**Consultation Response from KC,
Highways Development Management****2026/91437 Blacker Farm, Park Lane, Emley, Huddersfield, HD8 9QS****Alterations to existing building to form 3 dwellings, demolition of stables and erection of 2 dwellings with associated works****Date Responded: 30 June 2026****Responding Officer: Sheila Henley****Responding Ref: K17-23/8****Recommendation: Additional information and revisions**

Plan ref: H_01_SP - access 1; H_01_SP - access 2; H_01_SP – access; 340-25-PL01 rev B3340-25-PL03 rev A - Access Road; 2496-0001 - Fire Tender Vehicle Tracking

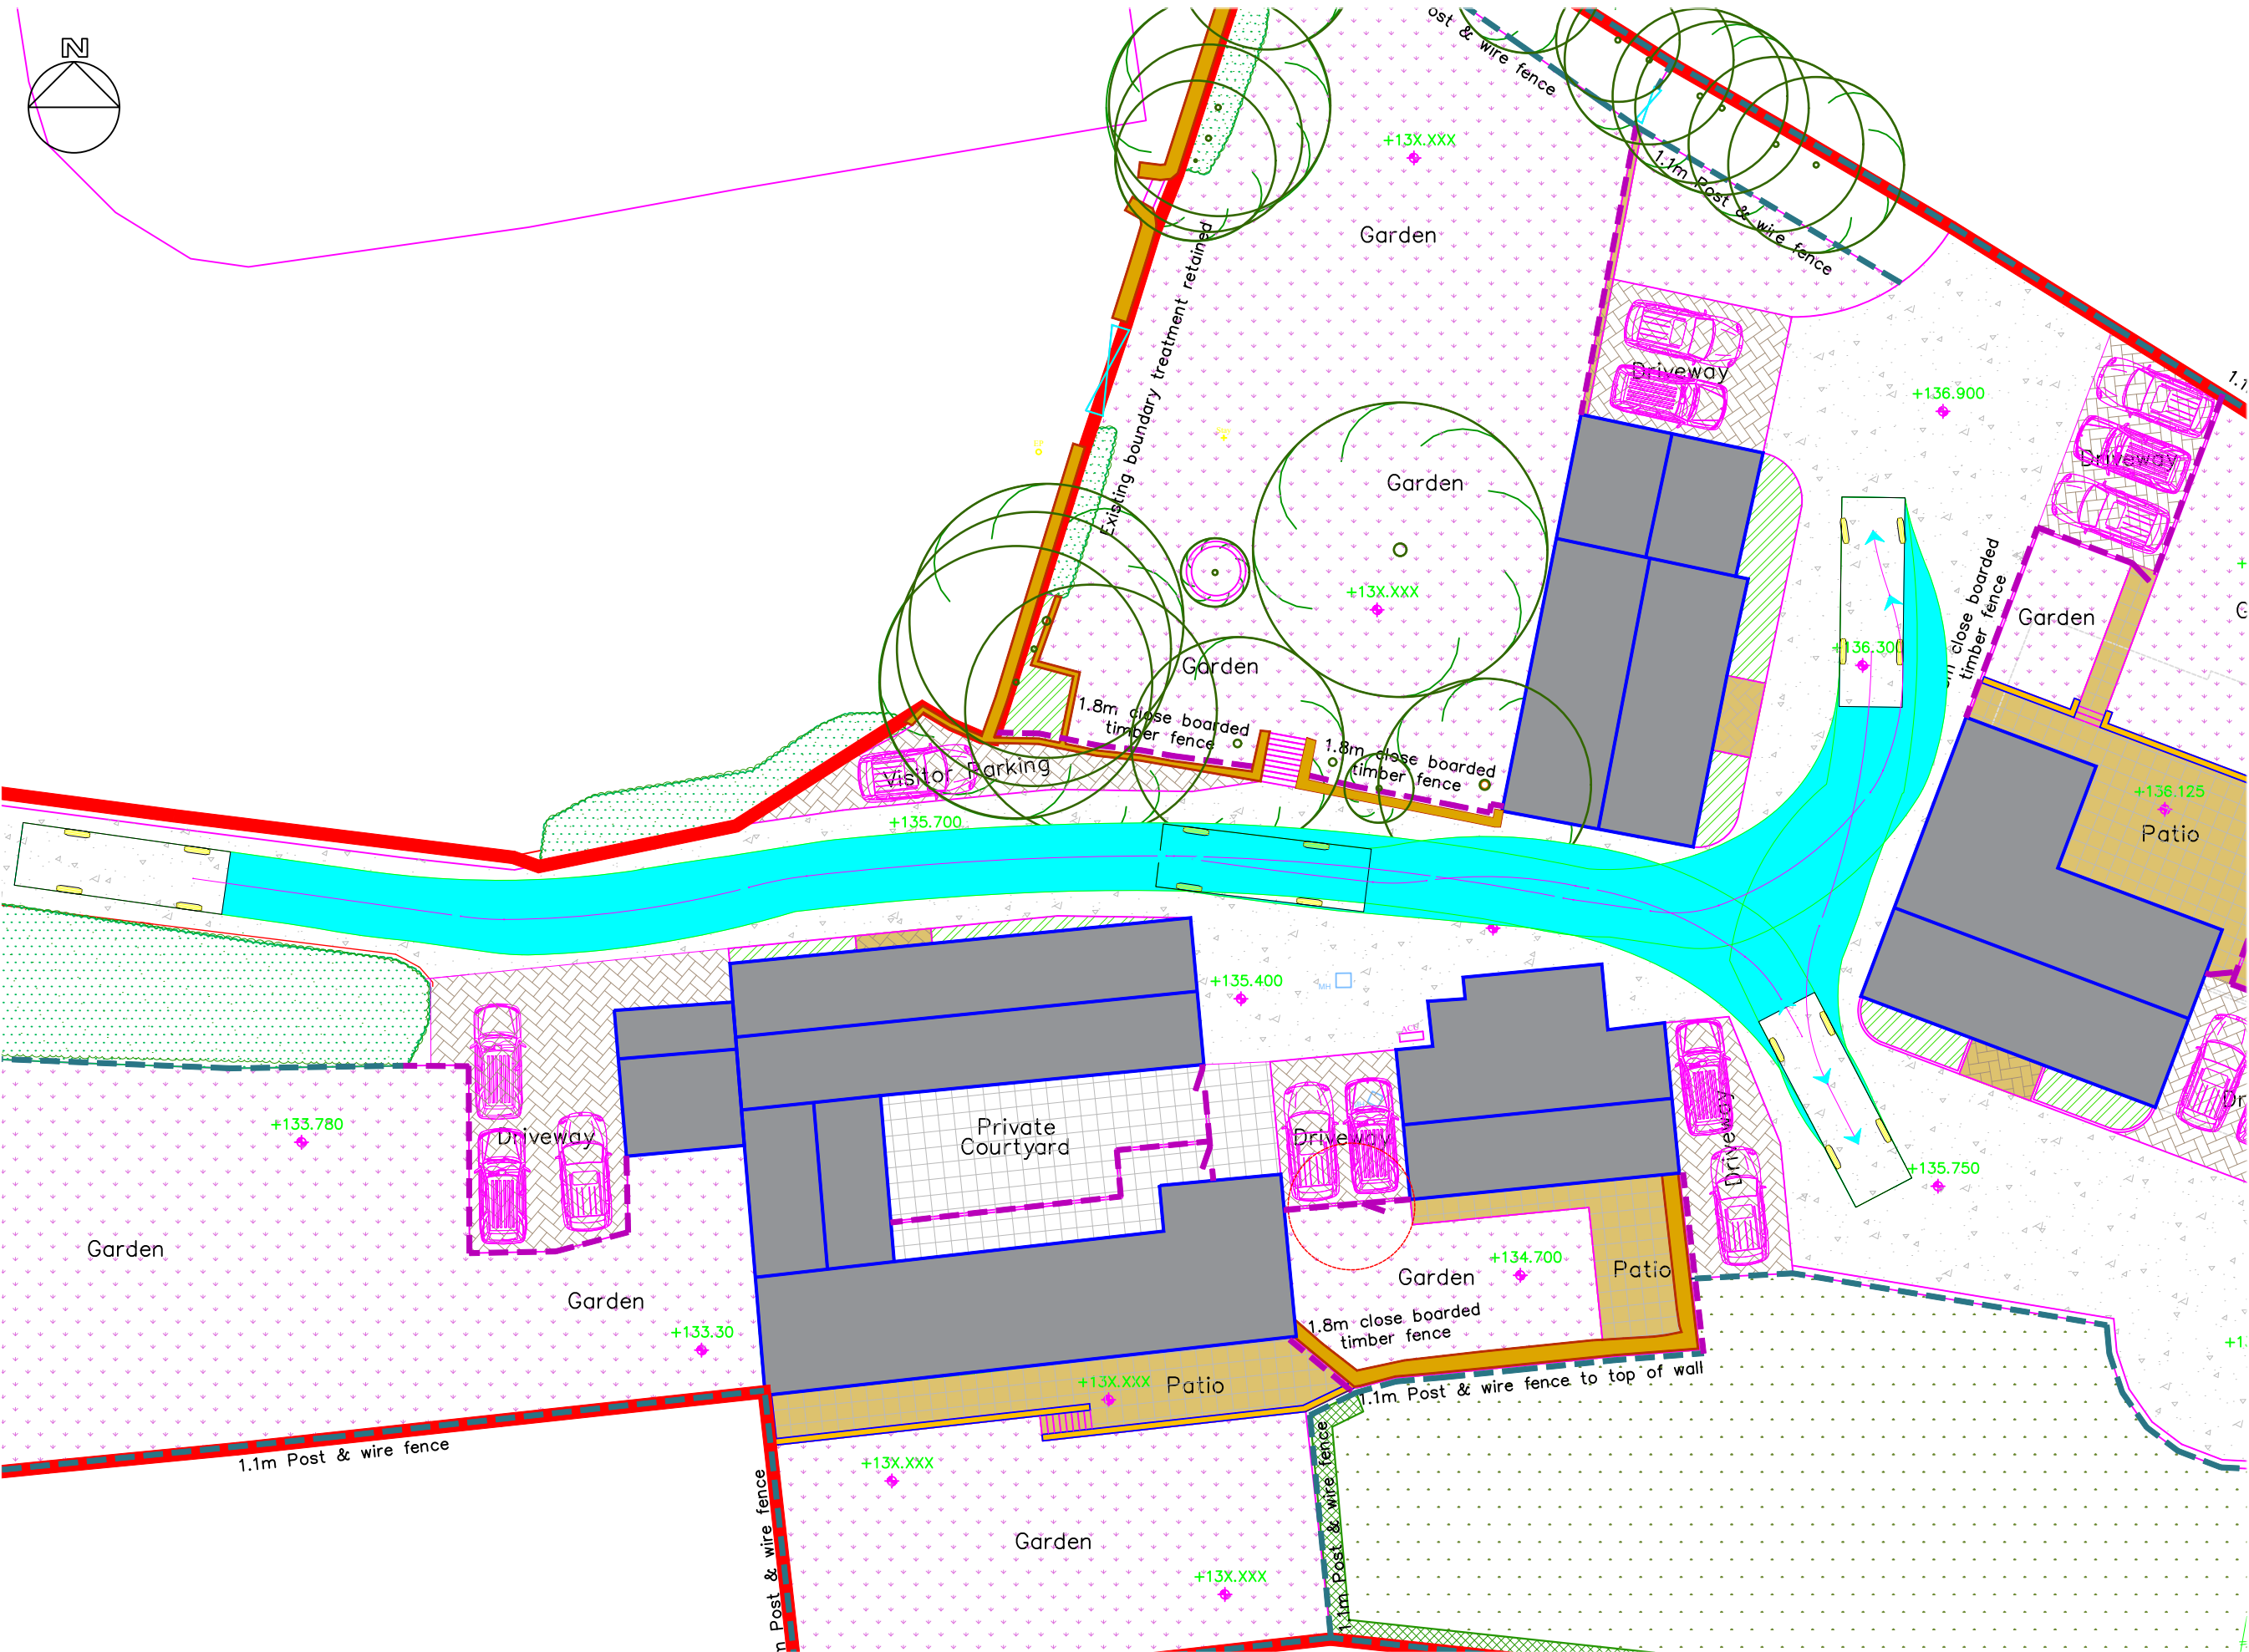
It is noted that fire and rescue services would be able to reach within 45m of the existing and proposed dwellings as demonstrated by the submitted swept path analysis.
